October 3rd 2019.

**Additional Tree Impact Appraisal, project at Greenbottom Farm,
Hoylandswaine.**

I have already written an impact appraisal regarding the elderly Ash tree on this site. This letter is to address the project's impact on the roadside trees. I understand that the route of the driveway has now been altered slightly and I have been sent a copy of a "Landscape Master Plan" prepared by PWP Design (ref PWP.256.001 rev 1), which shows some roadside trees removed.

TREE LOCATION PLAN
 SITE AT GREENBOTTOM FARM
 NOT TO SCALE
 ADAPTED FROM SUPPLIED PLANS
 17.04.2019.

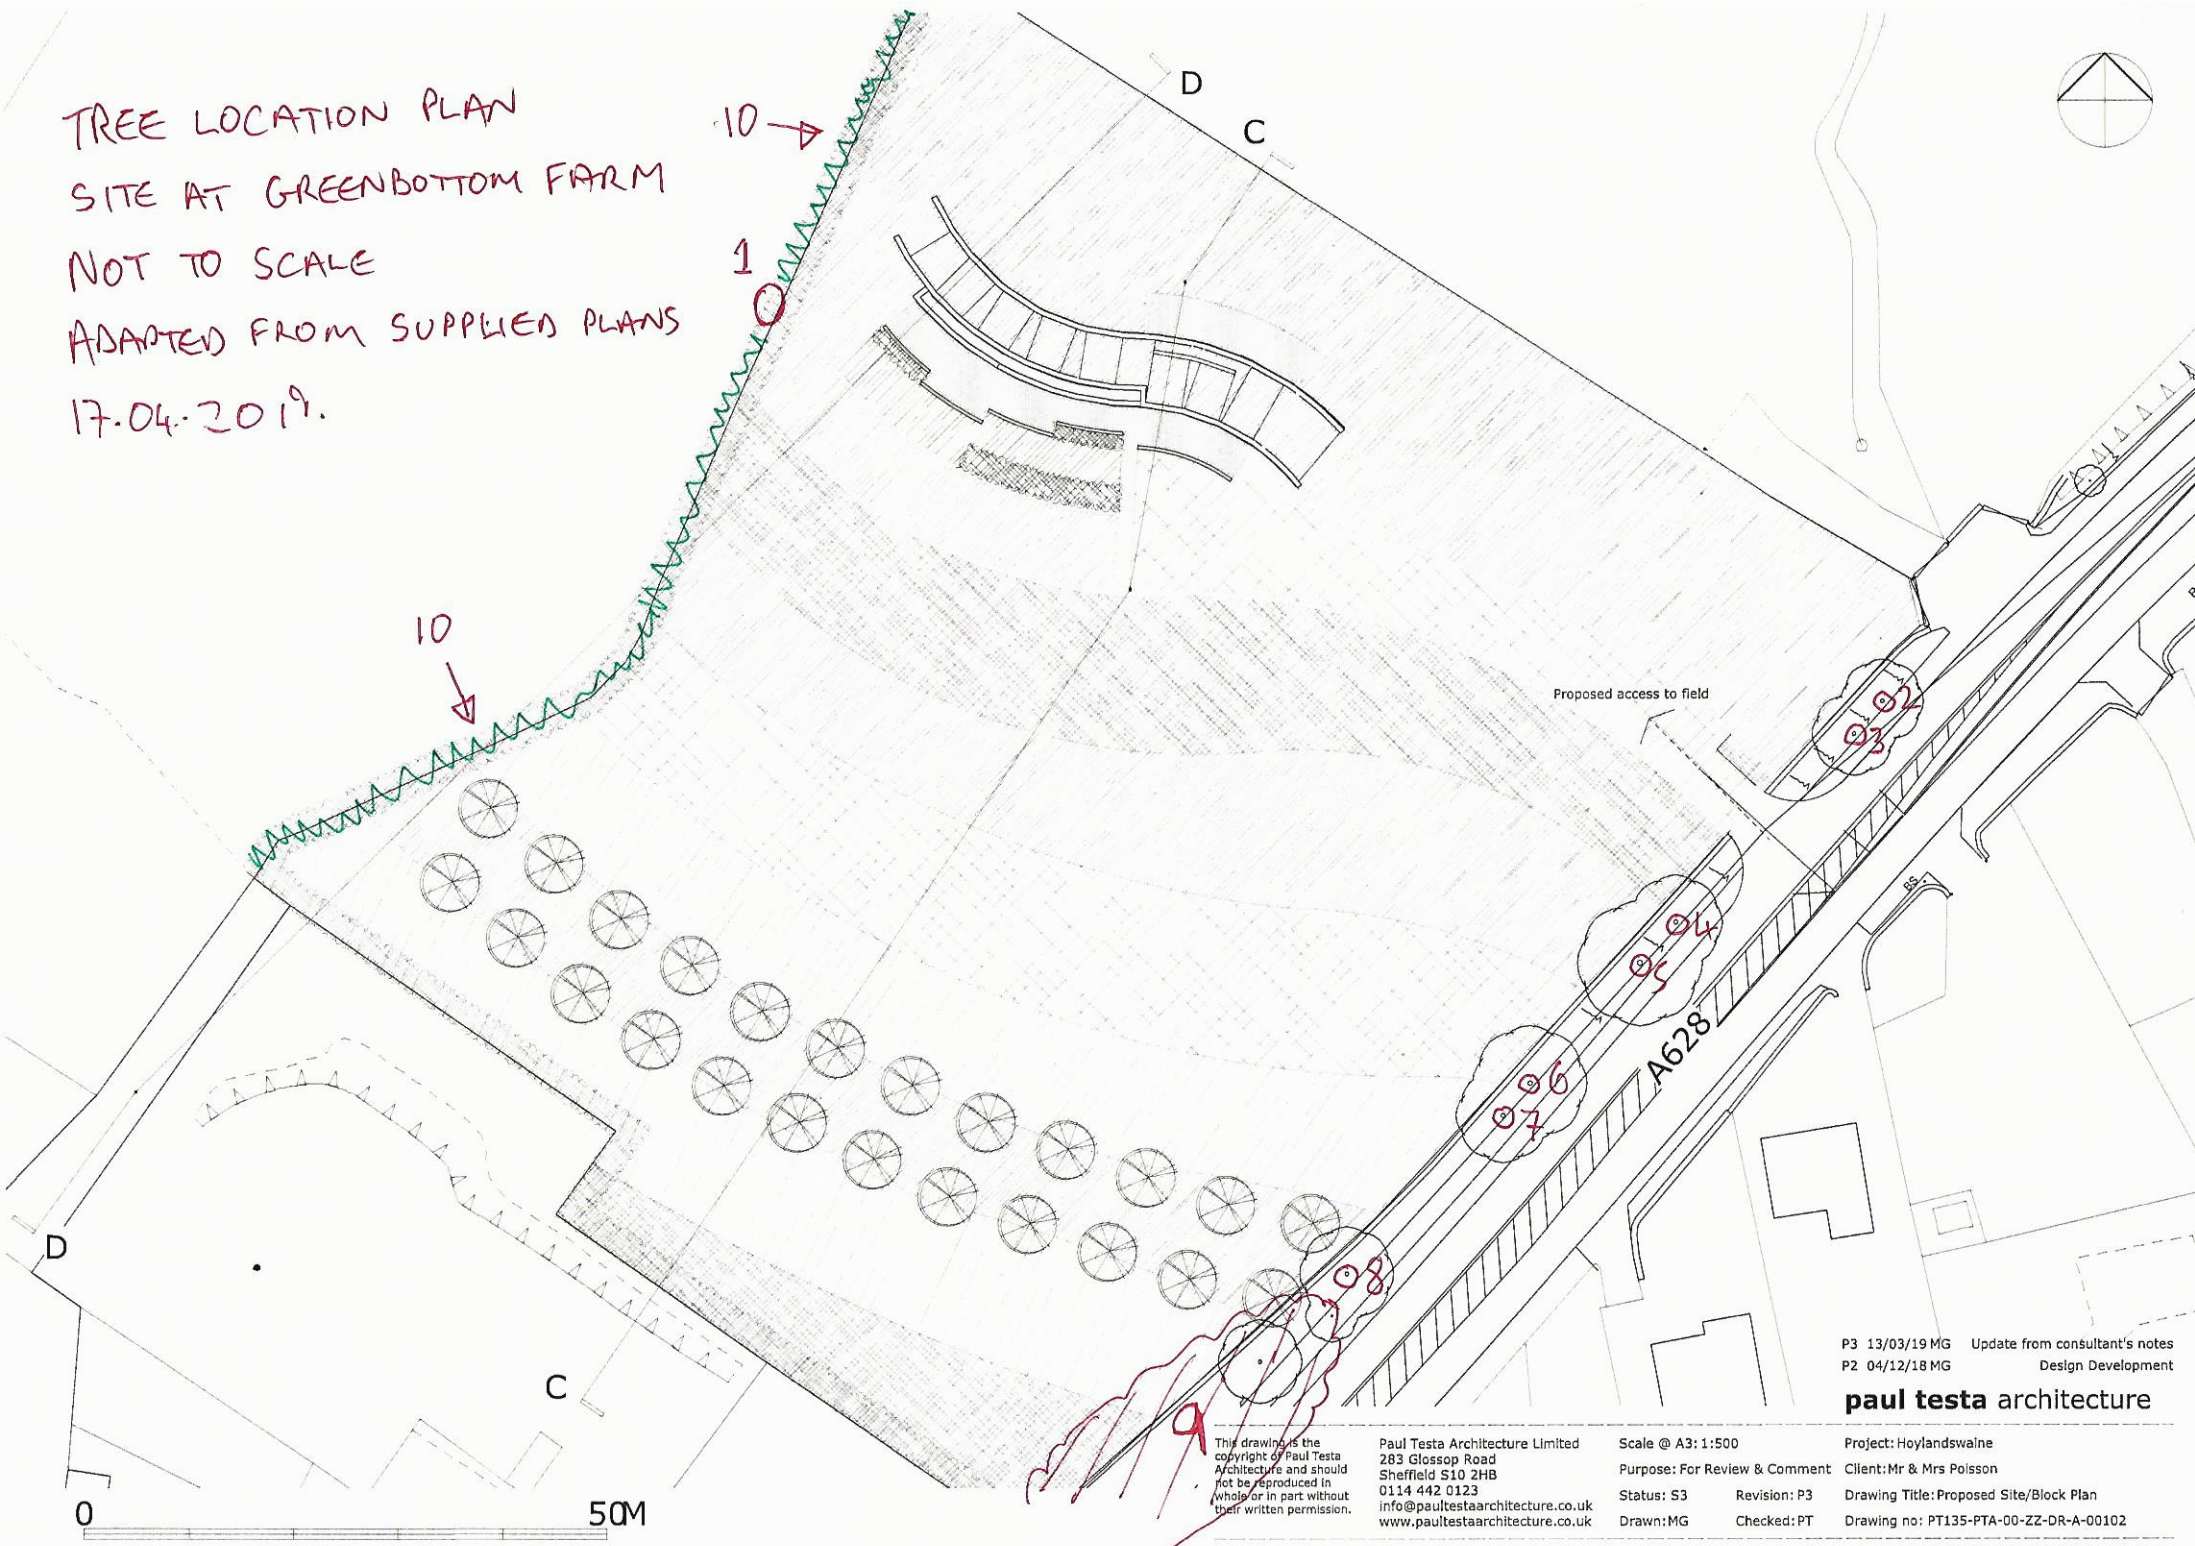
The landscape plan shows trees 5, 6, 7, & 8 removed. These are all Ash trees and My report noted nothing of any particular merit about them. It seems they will simply be cut down to allow a better view of approaching traffic from the south for vehicles leaving the site. I note that the landscape plan shows new trees planted further into the site to leave the "visibility splay" clear.

I'm not entirely sure why the landscape designer hasn't seen fit to remove tree 4 (Norway Maple) but if it is to be retained I imagine it will need some lower branches removing so the view along the highway to the south is not obstructed. This is really no different to what is likely to be required whether or not the site is redeveloped, as the tree has a large lower branch (really a secondary stem) that will soon be obstructing the footpath at the side of the road. (This should have been removed when the tree was a sapling.

1. I consider the removal of the Ash trees (5 to 8 in my original tree survey) to be insignificant.

2. I consider that replacing the lost trees with new ones planted further away from the road, where the verge managers are not obliged to undertake tree pruning for which they are not trained, to be an improvement over the existing state-of-affairs.
3. The pruning of the Norway Maple closest to the proposed driveway is likely to be necessary whether this development takes place or not.
4. The impact of this proposal on the roadside trees is negligible and the impact on the neighbourhood's landscape and biodiversity is similarly small.
